**KIRKLEES METROPOLITAN COUNCIL
INVESTMENT & REGENERATION SERVICE**

DELEGATED DECISION TO DETERMINE PLANNING APPLICATIONS

Reference No: 2021/62/93211/W

Description: Erection of single and two storey rear extension and exterior alterations

Proposed Site Plan 1:100 @ A1

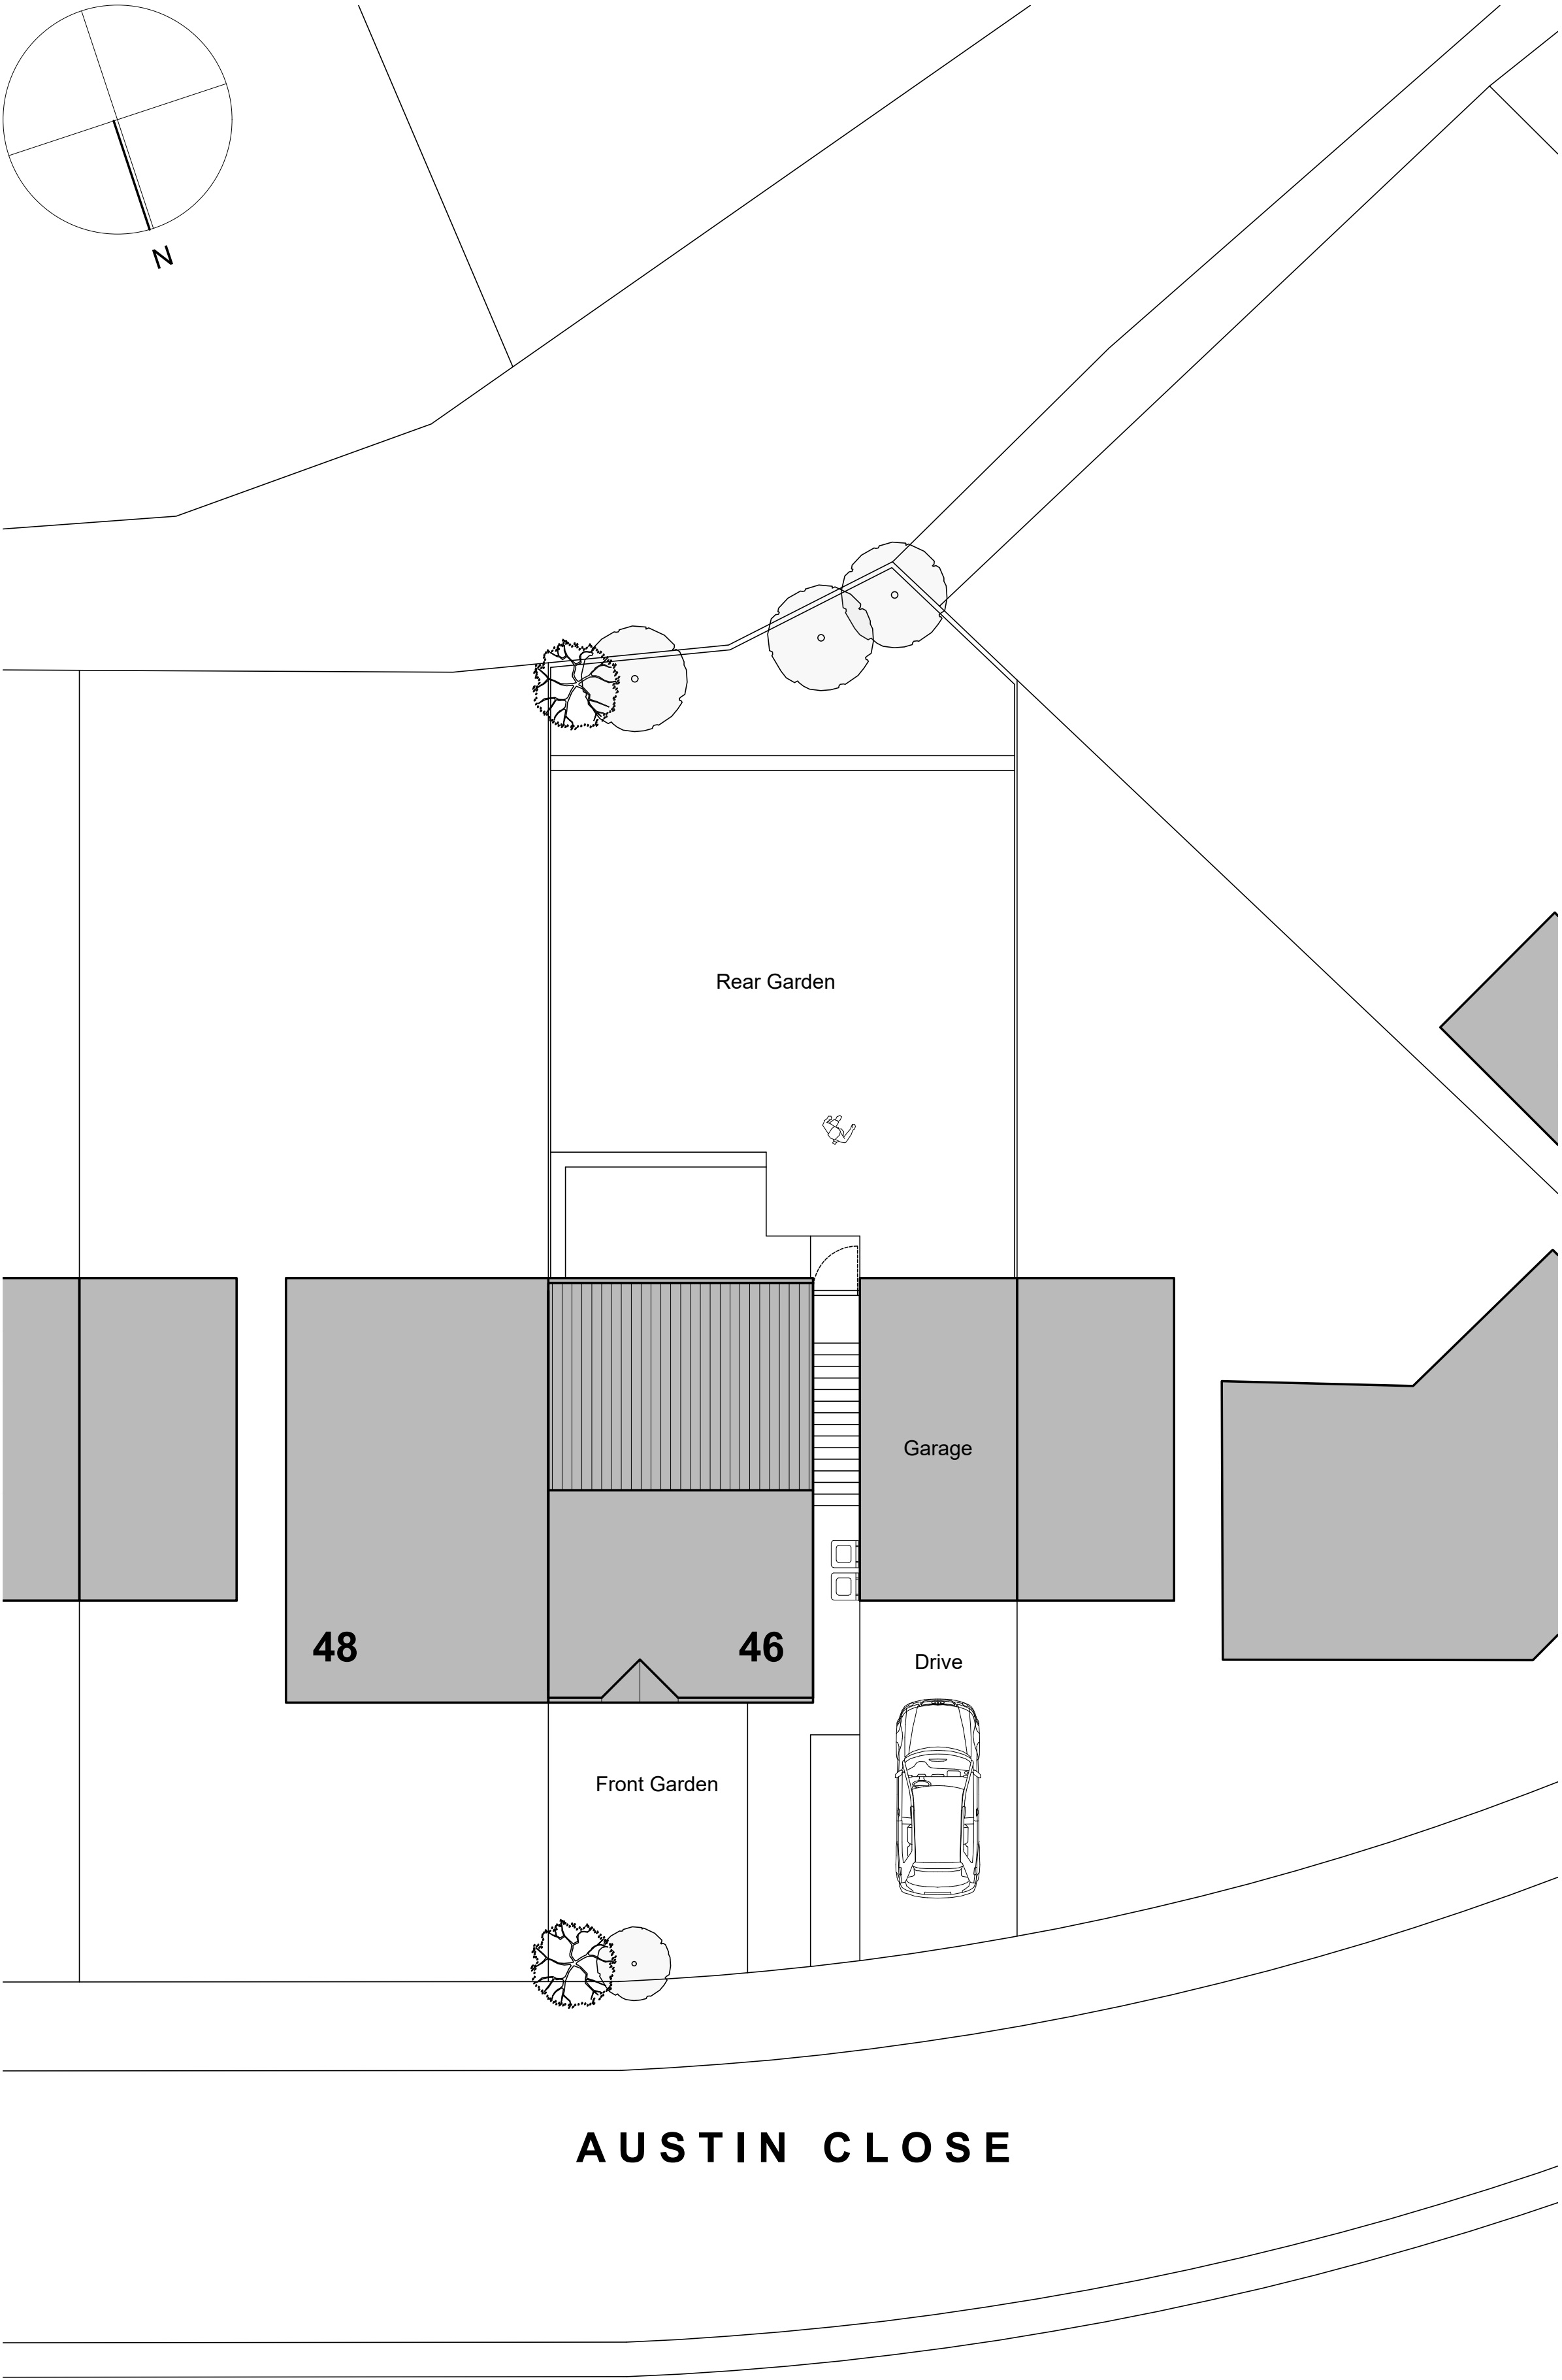
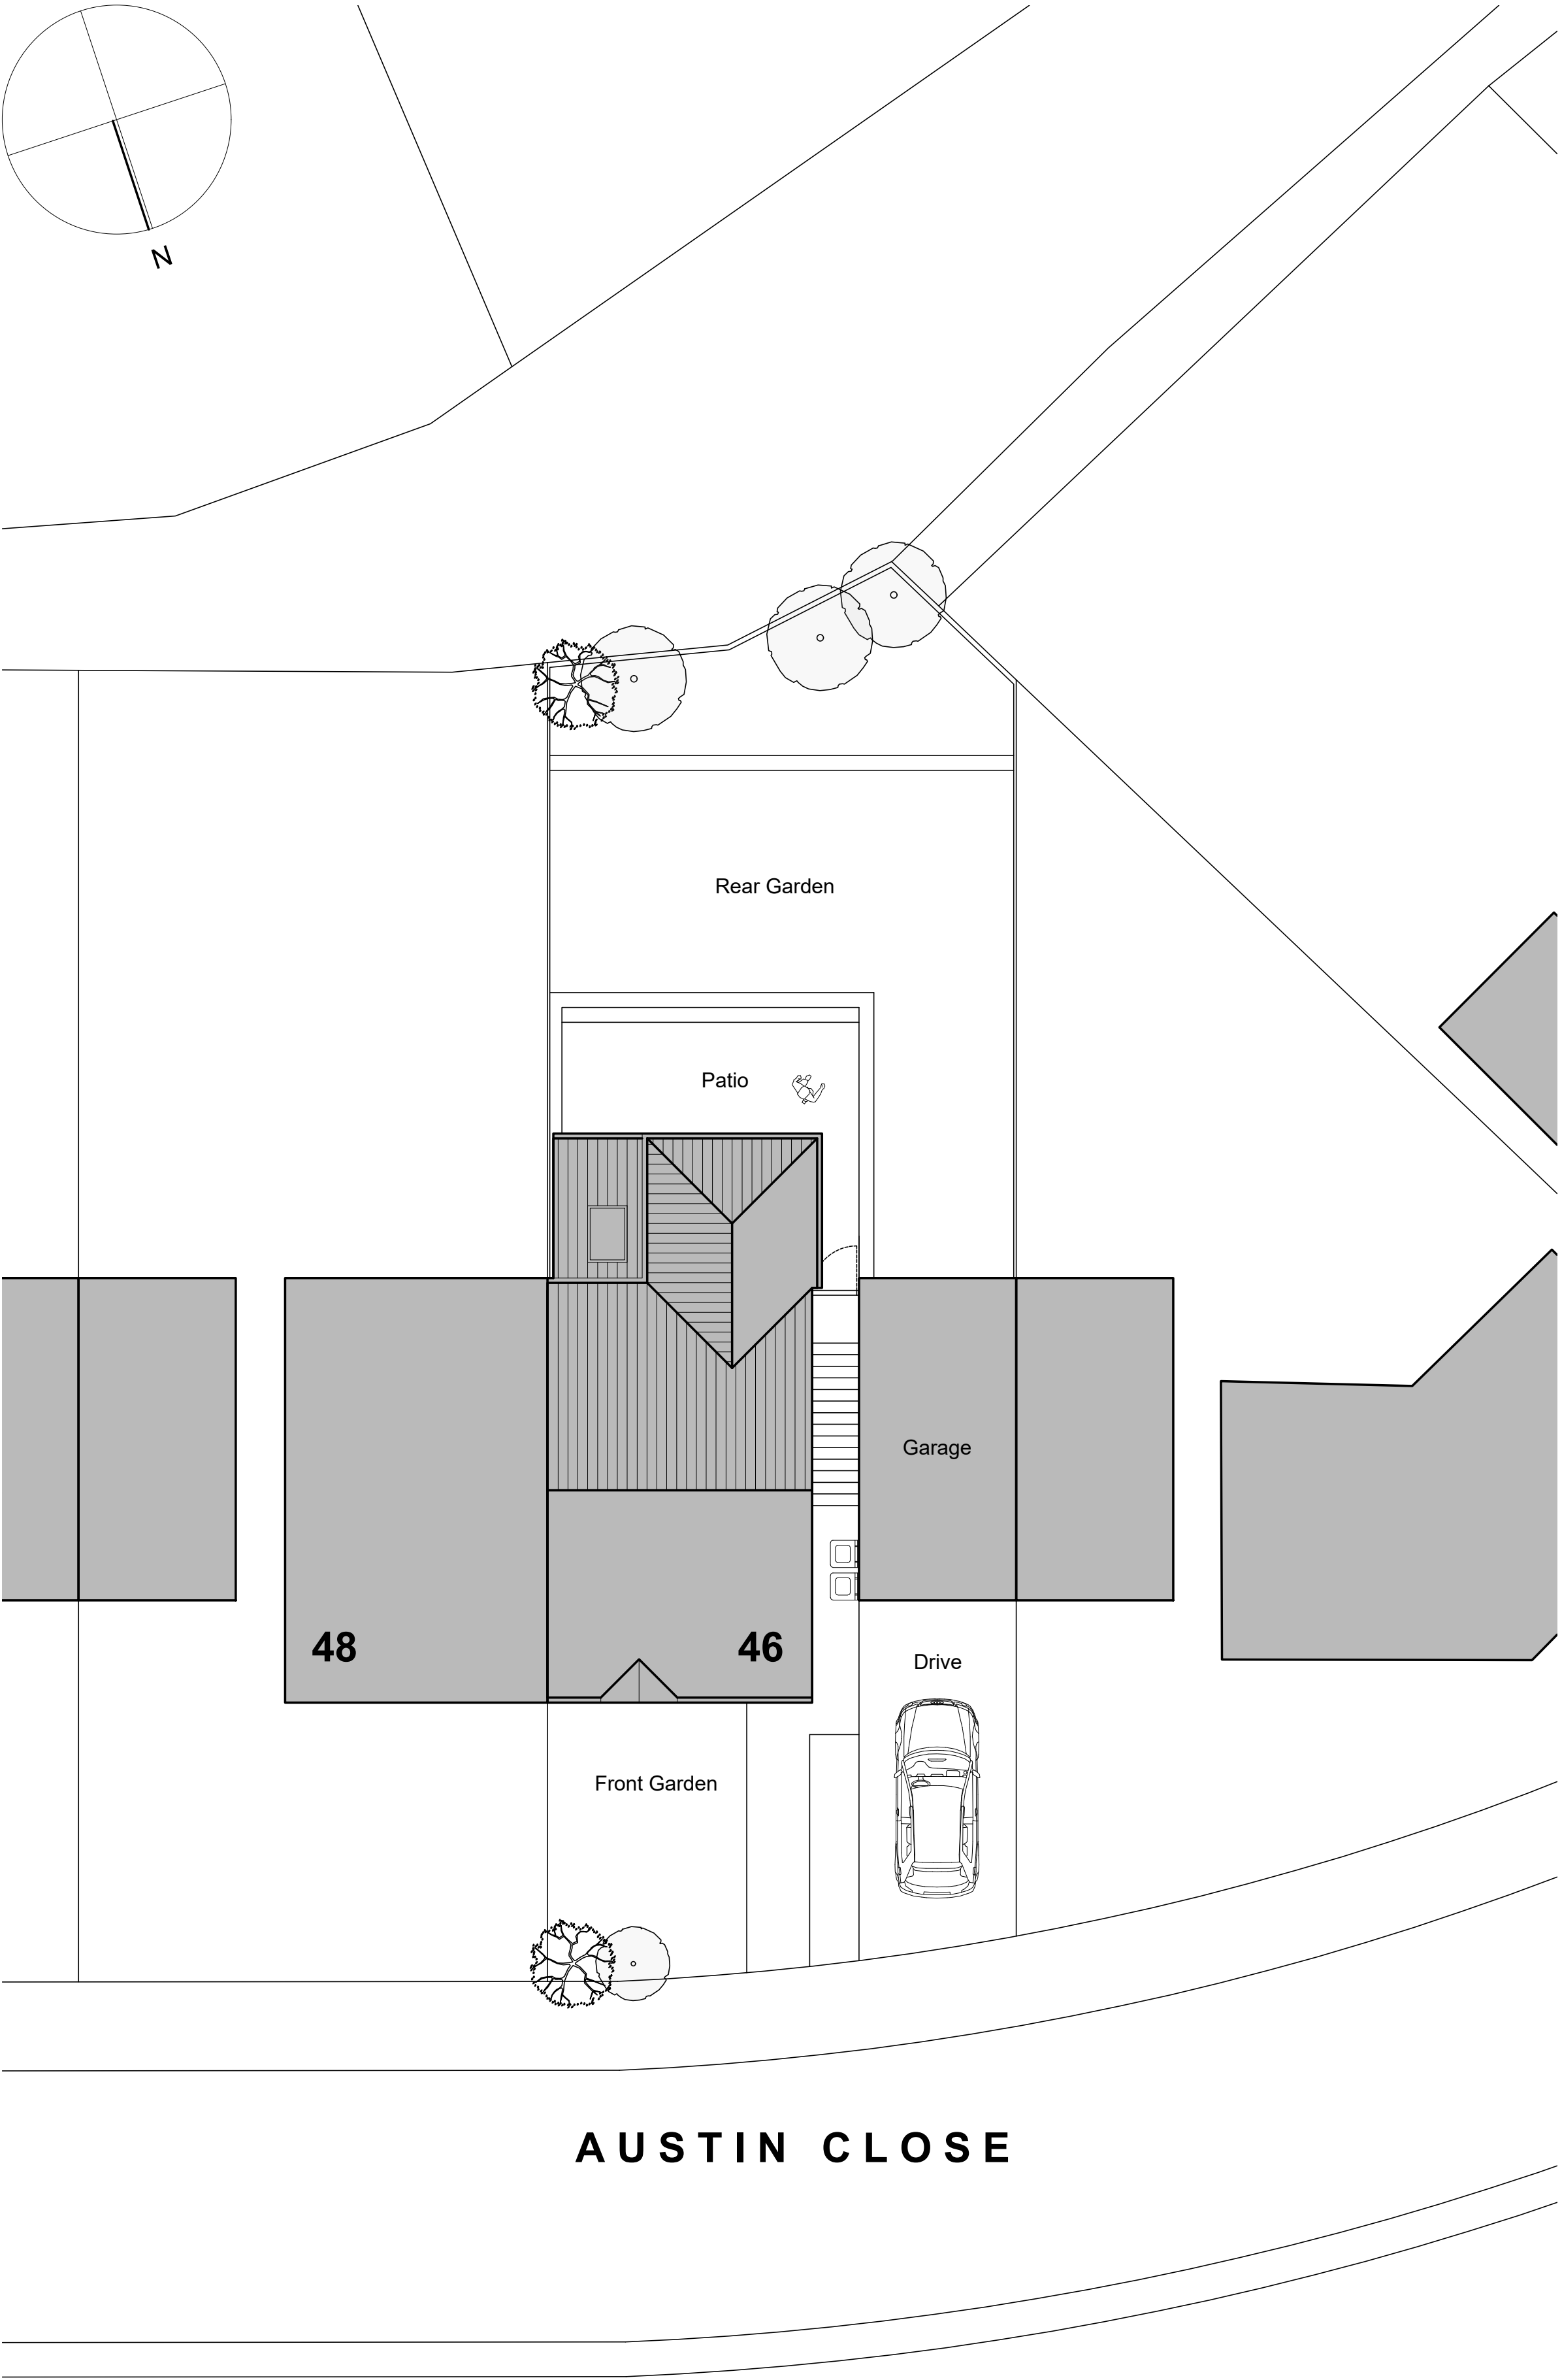
The proposed single storey extension in this case would be built close to the boundary with No. 48 which is to the south of the application site where the extension would have an overall projection of 3m with a lean-to roof having an overall height of 3.4m. This part of the proposal would comply with the Supplementary Planning Document for household extensions and could also be constructed under permitted development rights were it single storey only.

The neighbour to the north (No.44) is over 8m from the proposed two storey extension, where the existing garages in part would provide some screening along with the existing boundary fence. Therefore, the rear extension is considered to have a limited overbearing or overshadowing impact upon this neighbour given the separation distance and position of the extension.

The properties to the rear are at a slightly higher level with an existing separation distance of 30m which would be reduced to 27m, retaining adequate separation distance for the current situation and for future extensions for both these properties to ensure no significant overbearing, overshadowing or overlooking occurs.
